City of Albuquerque Stormwater Construction Site Inspection Report

Project Name:	Montecito Vistas				
Location:	Vista Vieja				
Site Contact Name & Agency	Troy/Dan - Pulte	ESC File No.	D09E005		
	troy.crutchfield2@pulte.com	NPDES Id. No.	NMR100BZ		
Inspection Date:	03/18/20	Start/End Time:	0800/0855hrs		
CoA Stormwater Inspector:	Timothy E. Sims				
Construction Phase:	home construction				
Type of Inspection:	<input checked="" type="checkbox"/> Regular	<input type="checkbox"/> Storm Event	<input type="checkbox"/> Post Storm Event >0.25"	<input type="checkbox"/> 311/Complaint	<input type="checkbox"/> Follow Up

CUT BACK CURB DETAIL
NOT TO SCALE

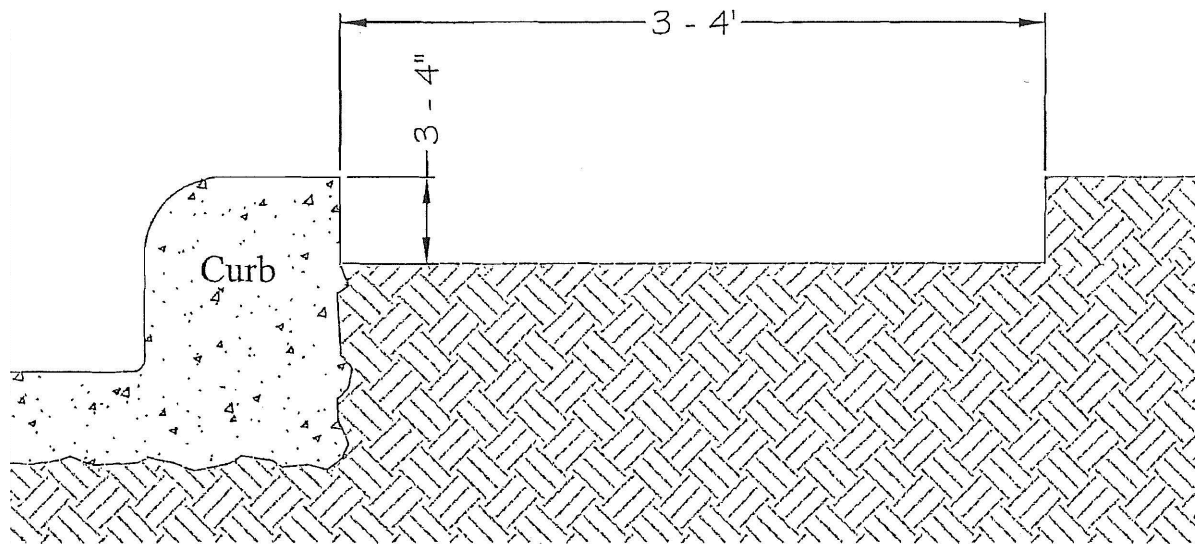
Item Number	Deficiency/ Corrective Action		
1	Please provide curb cut backs at lots being formed for slabs and infrastructure.		
	***Please provide latest SWPPP self-inspection report		
2.1	Discharge off site? (Y/N)	No	
4	Self Inspection Reports	requested	Latest report Date: 1/13/2020
